Submission No.			132	
Organisation Name or Name of Submitter			Irish Life Assurance plc. (Earlsfort Terrace Block C) - represented by Waterman Moylan	
Item No.	Section Ref.	Page No.	Observation Statement	TII Response
Re: Railway (Metrolink-Estuary to Charlemont via Dublin Airport) Order 2022 Earlsfort Centre Block C, Earlsfort Terrace, Dublin, D02 X668				
1	Submission 1	2	<p>The route selection, including horizontal alignment, vertical alignment and depth of MetroLink below ground in the area between Chainage 18+800 and Chainage 18+900, should be reviewed by NTA / TII to satisfy themselves and to ensure that</p> <p>(a) MetroLink does not cause structural damage to the foundation system supporting our client’s building which comprises a two-storey basement founded on the competent rock.</p> <p>(b) MetroLink does not cause structural damage to our client’s building at the basement level, any damage would result in the ingress of water into the basement.</p> <p>(c) MetroLink does not cause damage to the cladding; glazing and fragile finishes of our client's building.</p> <p>(d) MetroLink provides the necessary vertical and/or horizontal clearance between the existing basements and th

Drawing Status	FINAL	
Scale @ A3	1:10,000	DO NOT SCALE
JACOBS No.	32108600	
Client No.		
Drawing No.	ML1-JAI-EIA-ROUT_XX-DR-Y-14009	Rev P02

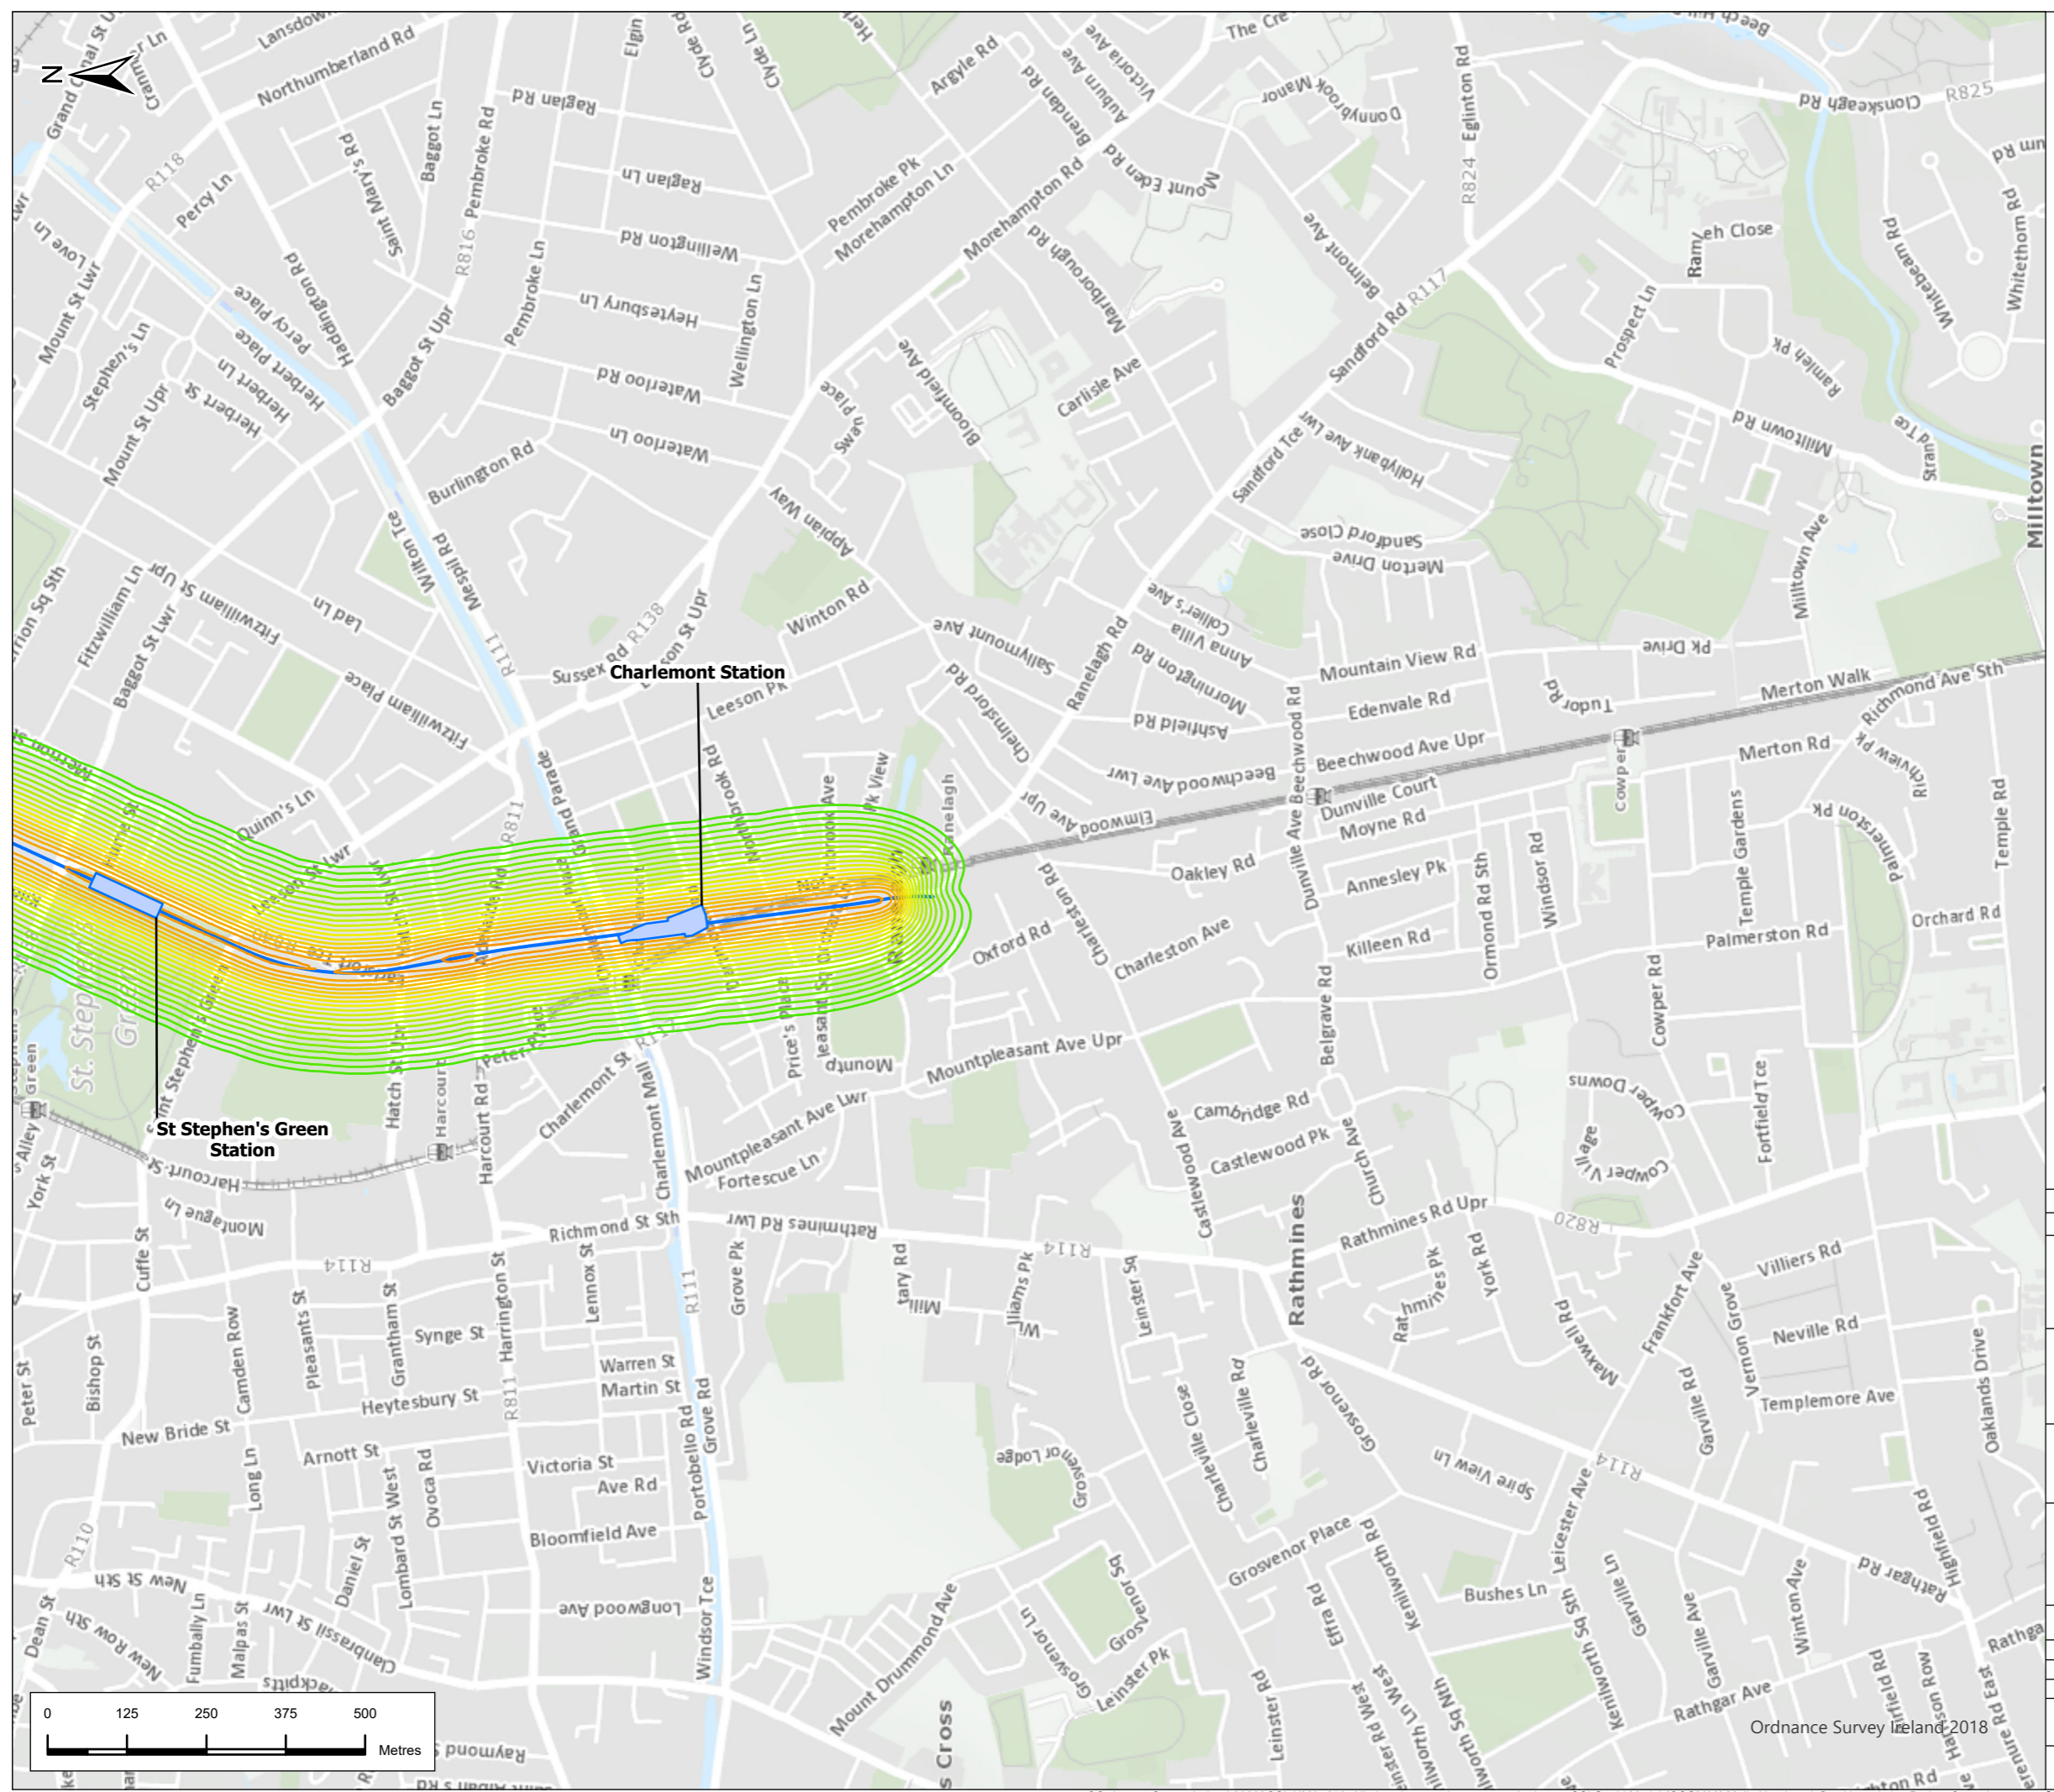
2	Submission 2	2	<p>a) Metrolink has assessed the “Groundborne Noise from Tunnel Boring Machine” and presents its findings on drawing no. ML1-JAI-EIA-ROUT-XX-DR-Y-14009 (a copy is attached to this submission). This drawing indicates MetroLink will generate an additional 50db directly under the location of our client's building which is unacceptable.</p>	<p>Appendix A14.5 Groundborne Noise and Vibration Blasting Modelling Results presents predicted groundborne noise and vibration levels during the construction and operation phase of the project. The prediction of groundborne noise during TBM passage for Earlsfort Terrace Block C is 49 dB LASmax, which is above the 45 dB LASmax threshold, resulting a significant impact on the building for the limited duration of TBM passage. It is important to note however that there will be no potential for damage to the building resulting. The duration of this impact will be in the order of up to two weeks as the TBM passes. TII will liaise with Irish Life Assurance plc. to ensure the timing of these impacts are known.</p> <p>The principal mitigation measures aimed at minimising impacts are as follows:</p> <ul style="list-style-type: none"><li>- Advance public consultation and stakeholder engagement can greatly reduce the significance of groundborne noise effects, as building occupants would be prepared for the passage of the TBM and resultant elevated noise and vibration levels.</li><li>- TII will accept and consider applications for additional measures on a case-by case basis, in accordance with its Noise and Vibration Mitigation Policy (see EIAR Appendix A14.6, Airborne Noise &amp; Groundborne Noise Mitigation Policy).</li></ul>

Drawing No.	ML1-JAI-EIA-ROUT_XX-DR-Y-21149	Rev	P02
-------------	--------------------------------	-----	-----

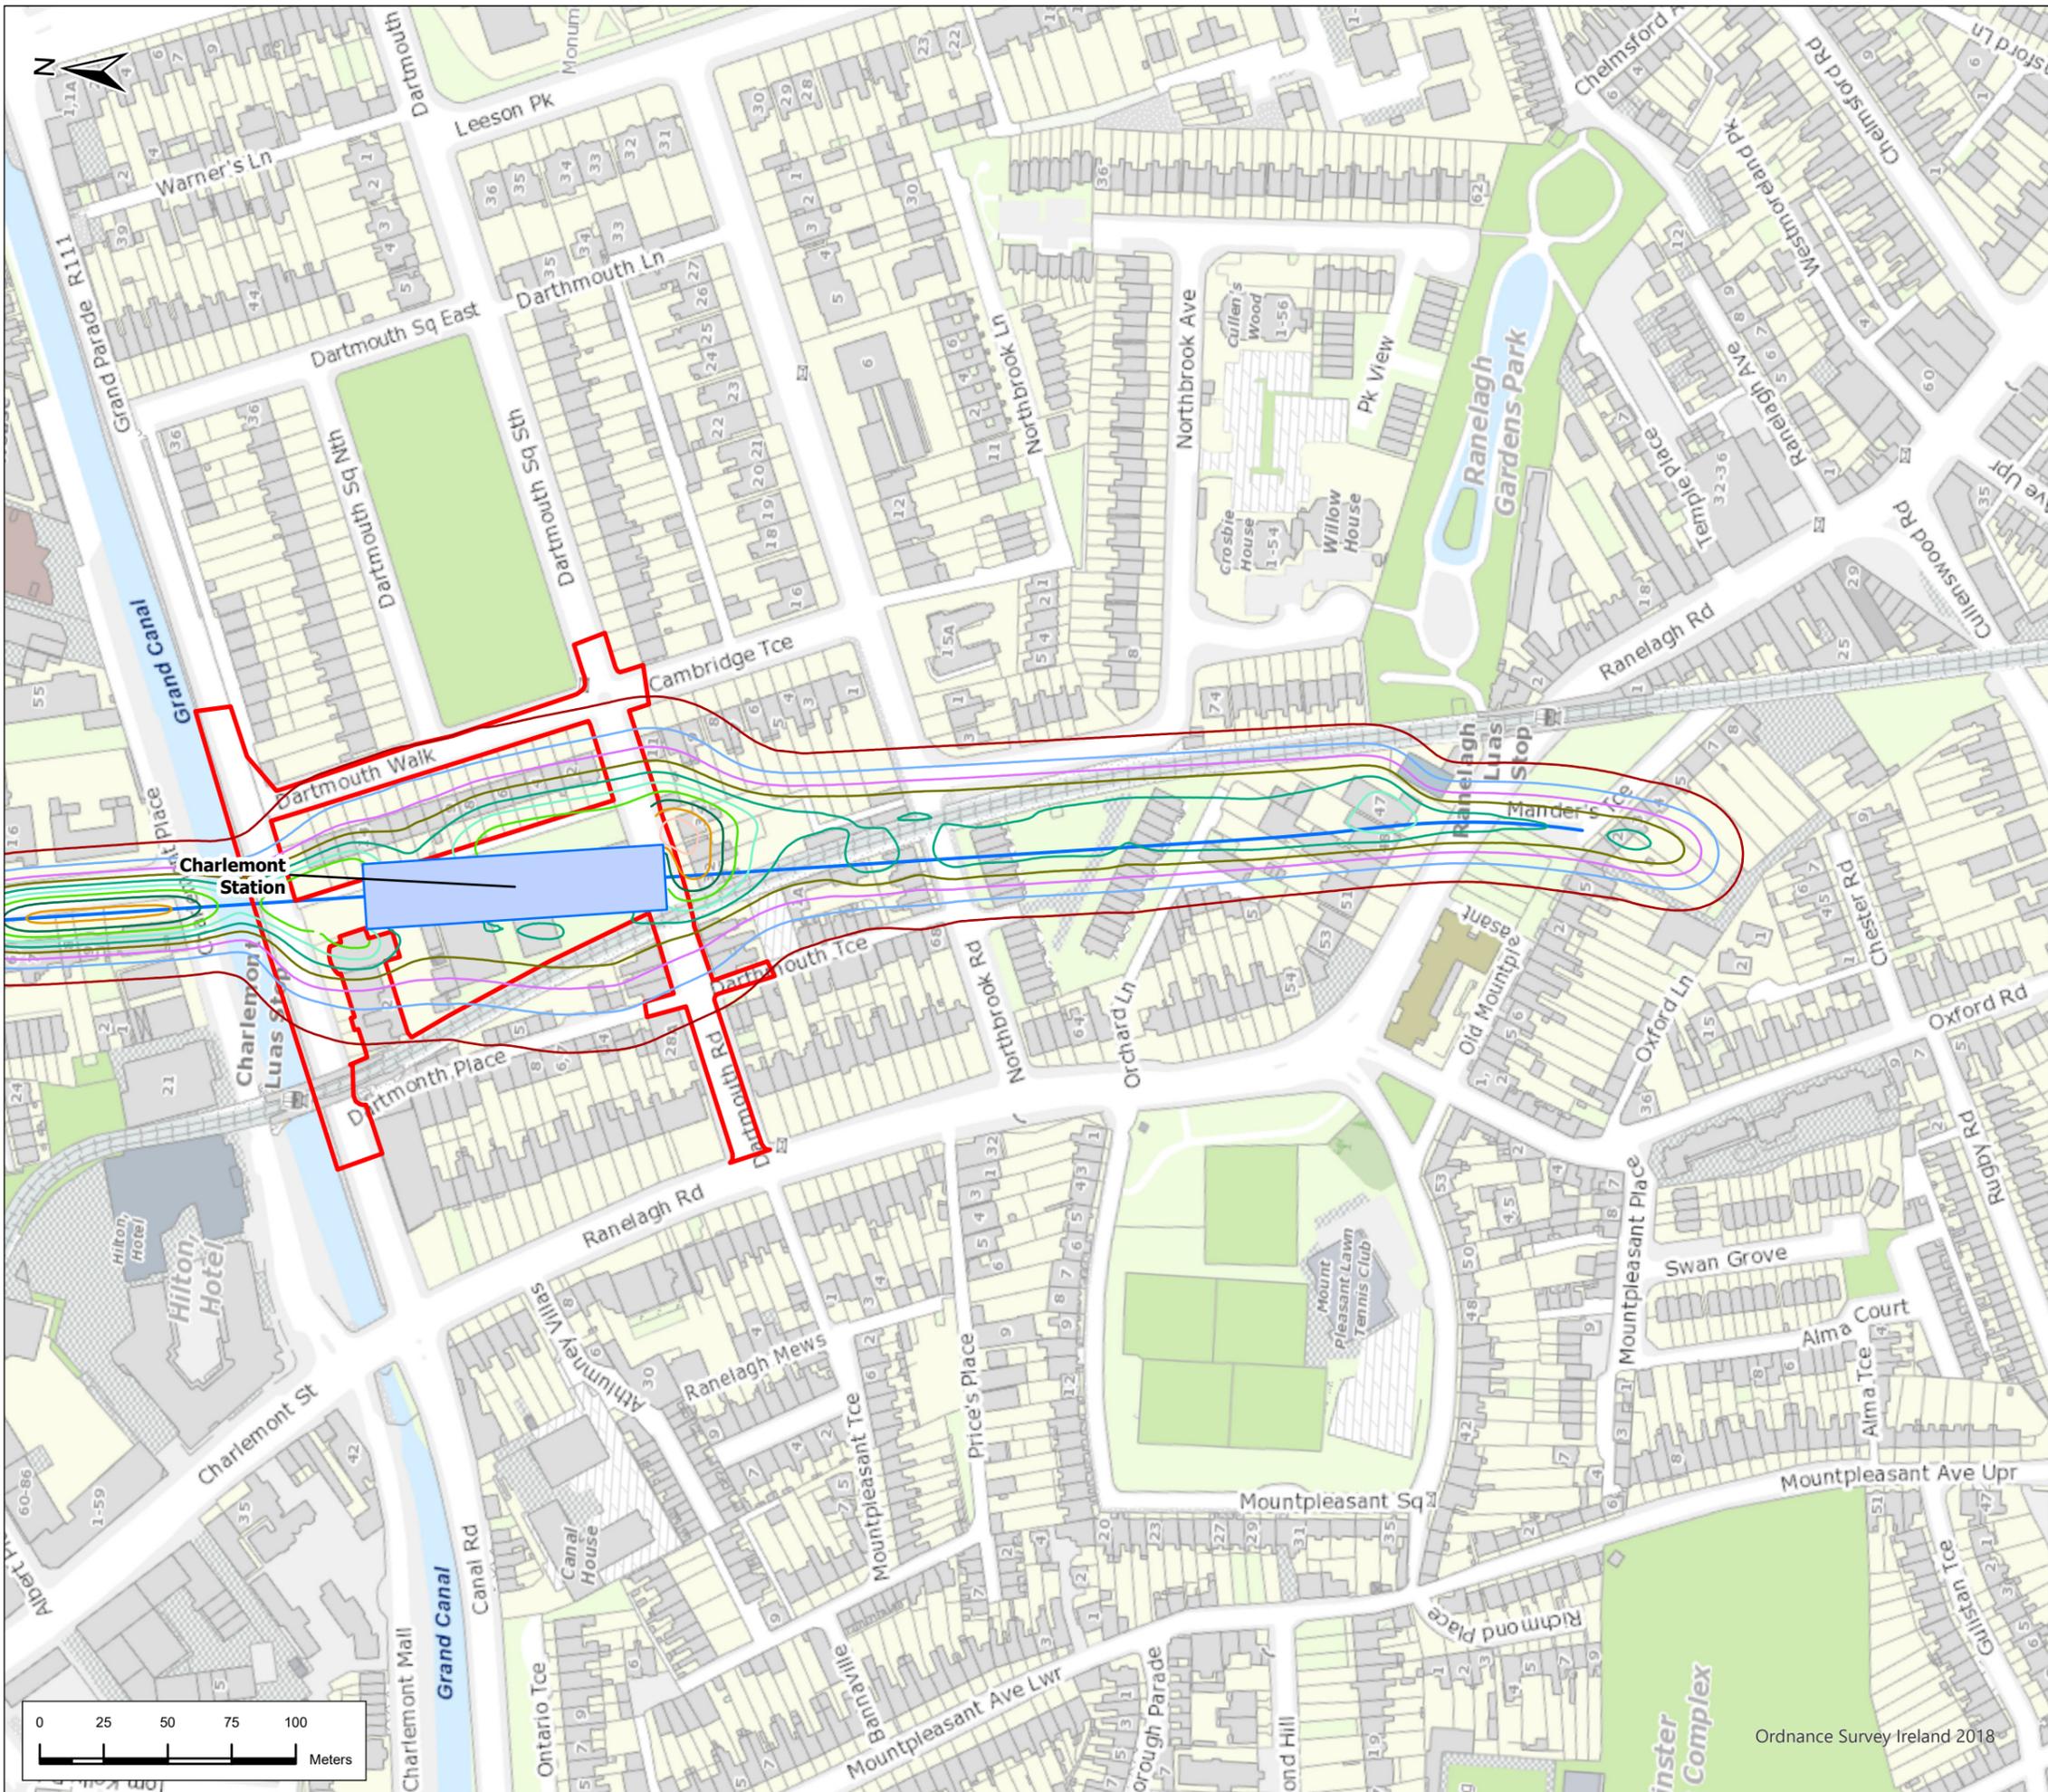
3	Submission 2	2&3	<p>b) Metrolink has assessed the predicted “Settlement” and presents its findings on drawing no. ML1-JAI-EIA-ROUT-XX-DR-Y-21149 (a copy is attached to this submission). This drawing indicates MetroLink will be causing a 40mm settlement directly under the location of our client's building which is unacceptable. Settlements of this magnitude cannot be accommodated by the building's structure and will cause damage to foundations; basement; superstructure; facade and internal finishes. As previously stated the basement structure forms the waterproof envelope to our client’s building and any damage would result in the ingress of water into the basement.</p>	<p>Please refer to Item 1. The settlement contours calculated were used to undertake the building damage assessment and conclude that damage would be limited to "slight / very slight" damage. The damage categories are described in section 4.3.2 of the EIAR Appendix A5.17, Building Damage Report. However, if the basement details are confirmed this assessment would be taken to Phase 3 as part of the further assessment procedure outlined in the EIAR Appendix A5.17.</p>
